FIVE ESTUARIES OFFSHORE WIND FARM

10.19 APPLICANT'S COMMENTS ON DEADLINE 1 SUBMISSIONS

Application Reference:	EN010115
Document Number:	10.19
Revision:	A
Pursuant to:	Deadline 2
Eco-Doc Number:	005416679-01
Date:	22 October 2024

SLR Cable drum vehicle
 Overall Length 25.660m
 Overall Width 3.000m
 Overall Body Height 4.900m
 Min Body Ground Clearance 0.427m
 Max Track Width 3.000m
 Lock to lock time 6.00s
 Wall to Wall Turning Radius 9.800m

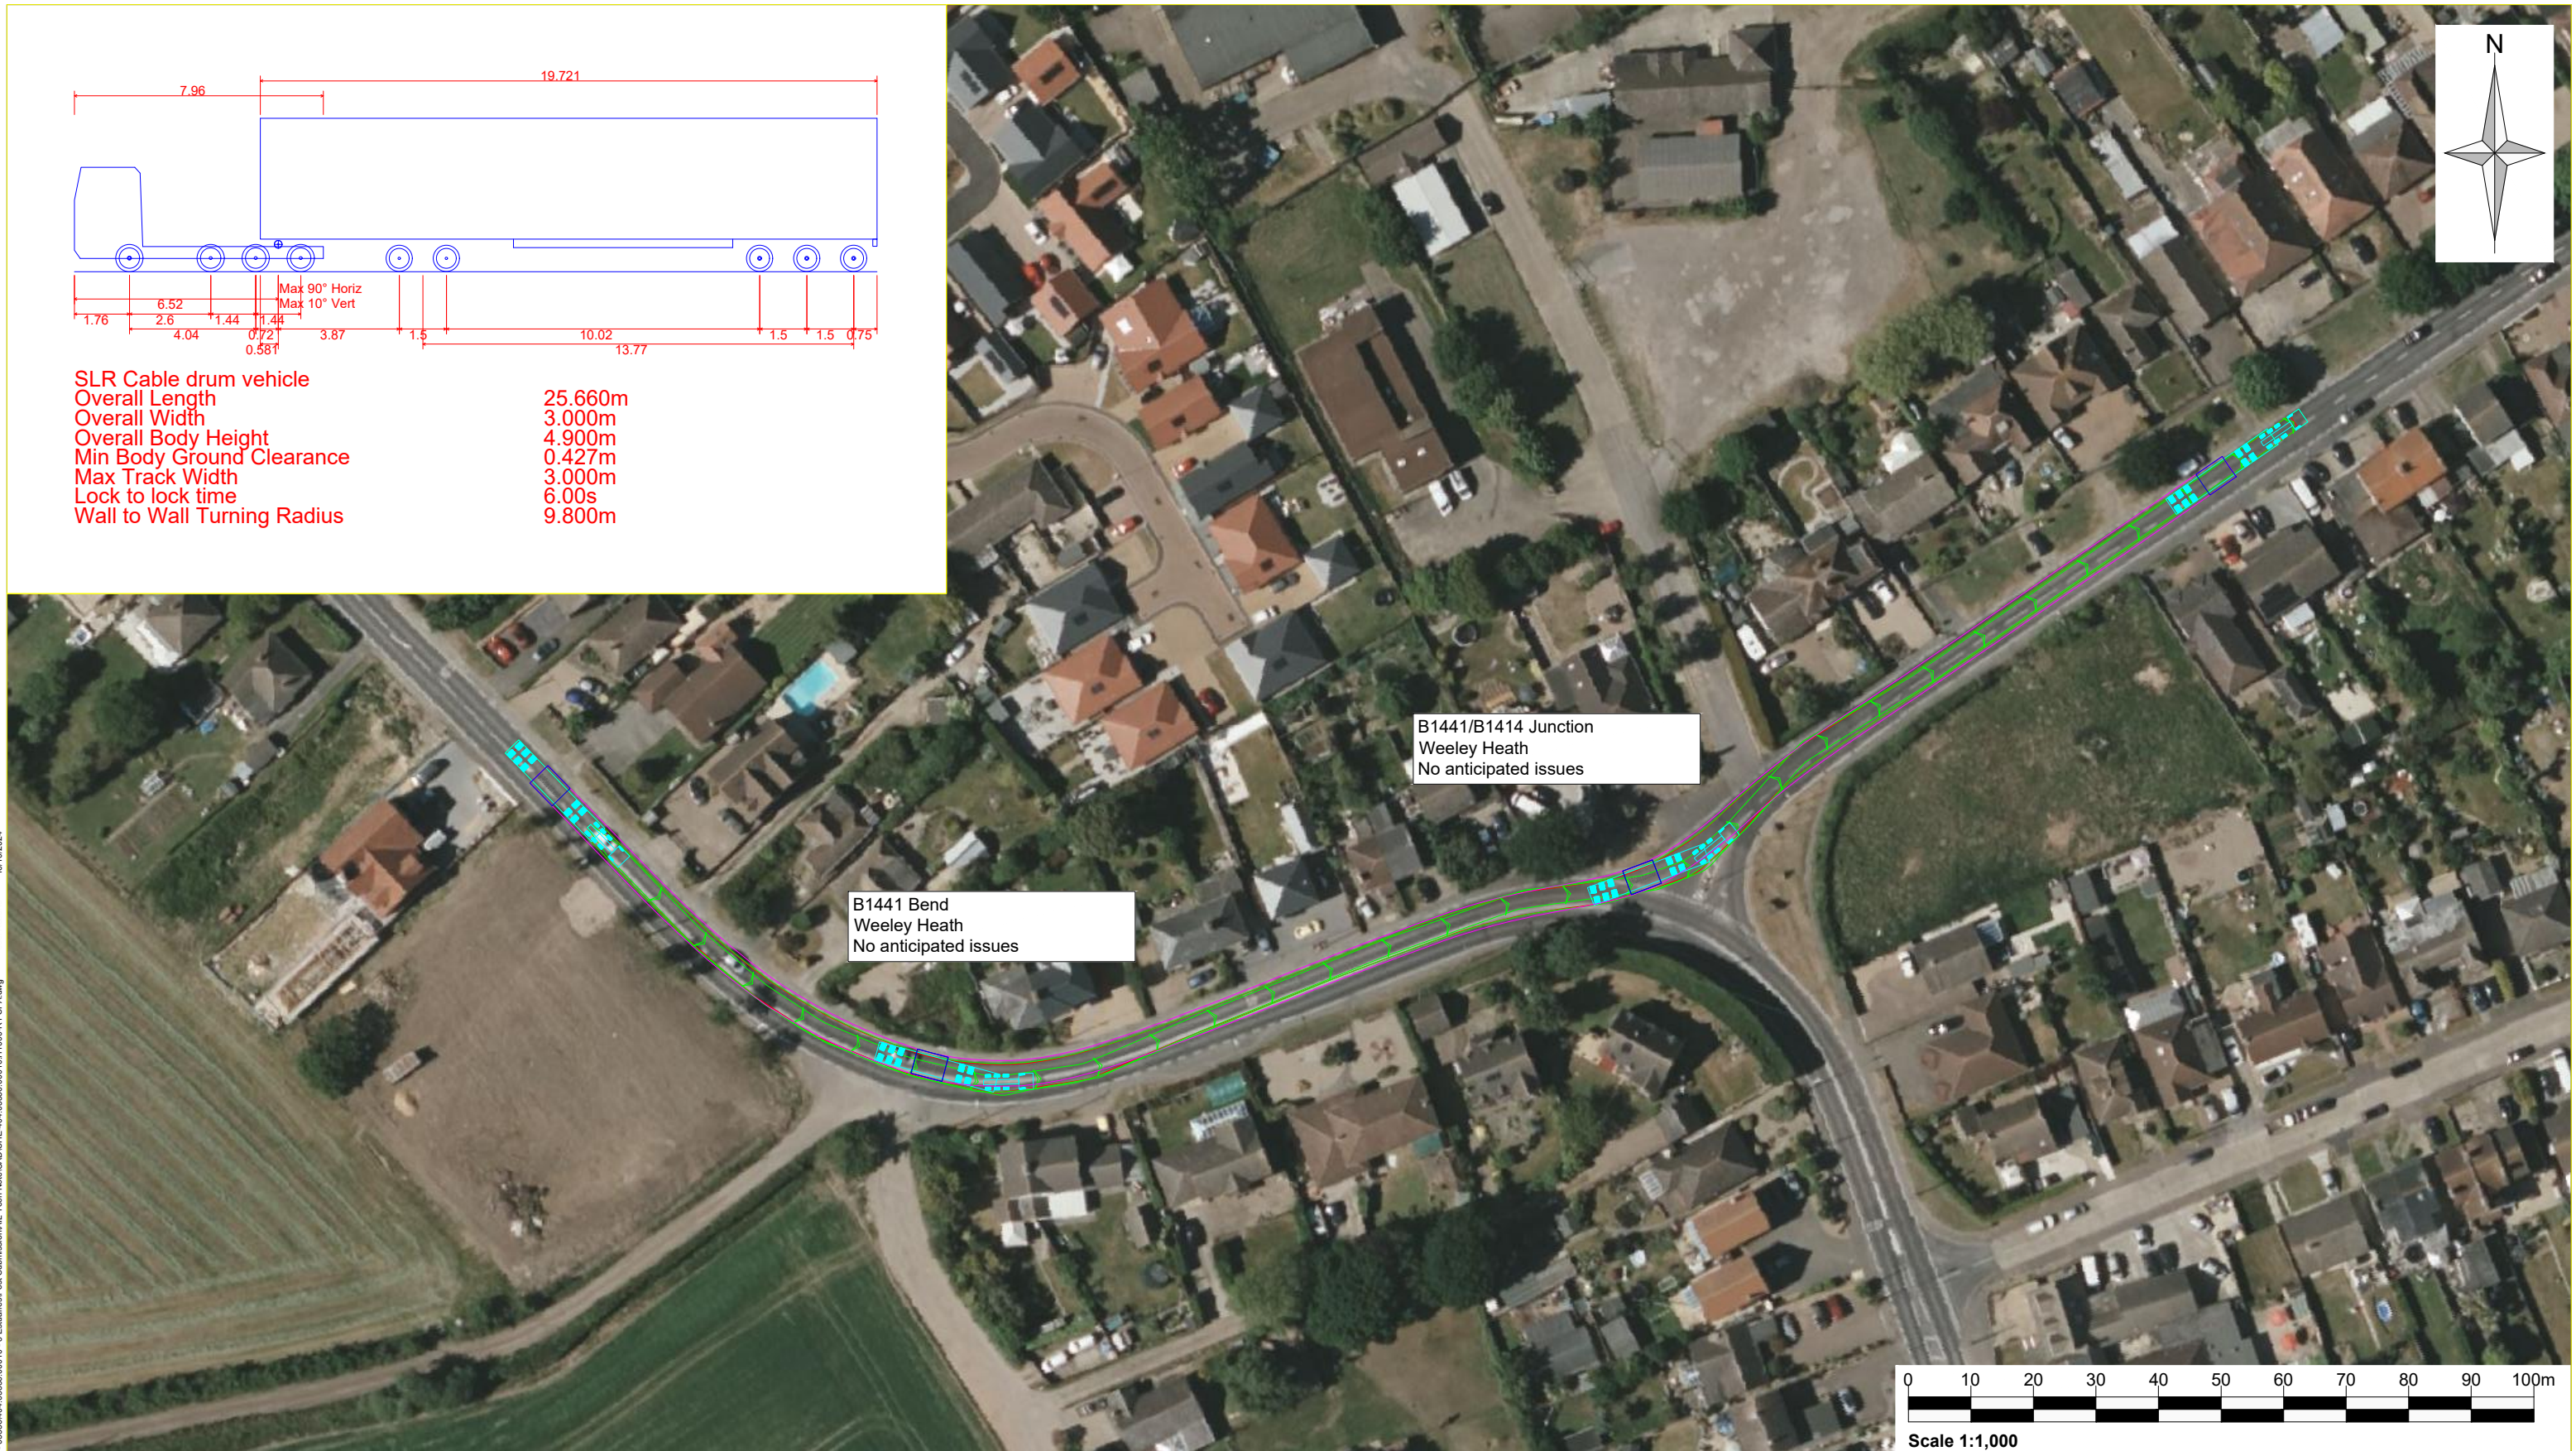
<p>AILs</p> <p>There is no reference to cable drum AILs within the Traffic and Transport chapter [APP-090], but it became clear at ISH1 that there is a requirement for these to access the proposed accesses on the rural road network. There are concerns around the routes for AILs for these cable drums associated with all of the accesses on the route, particularly the number and frequency. Clarity is sought on what assessment has been undertaken of the routes, including whether a structural assessment has been undertaken to ensure the deliverability of their routes i.e. can the local road</p>	<p>The Applicant has prepared an Abnormal Indivisible Load (AIL) Technical Note, which is being submitted at Deadline 2. This includes swept path analyses of the largest likely cable drum delivery vehicle on the highway network.</p> <p>There would be an estimate of 280 to 290 cable drum vehicle movements, which are included in the forecast construction vehicle movements set out in the Traffic and Transport chapter [REP1-018].</p>

network accommodate these movements. If an assessment has not been undertaken of the routes, it may be that they are not deliverable, and so would have to use alternative routes with different impacts. This presents a risk to the project. We would request that swept path drawings are provided at key junctions along these routes, and structures pinpointed along the designated routes with assessments undertaken of those structures.
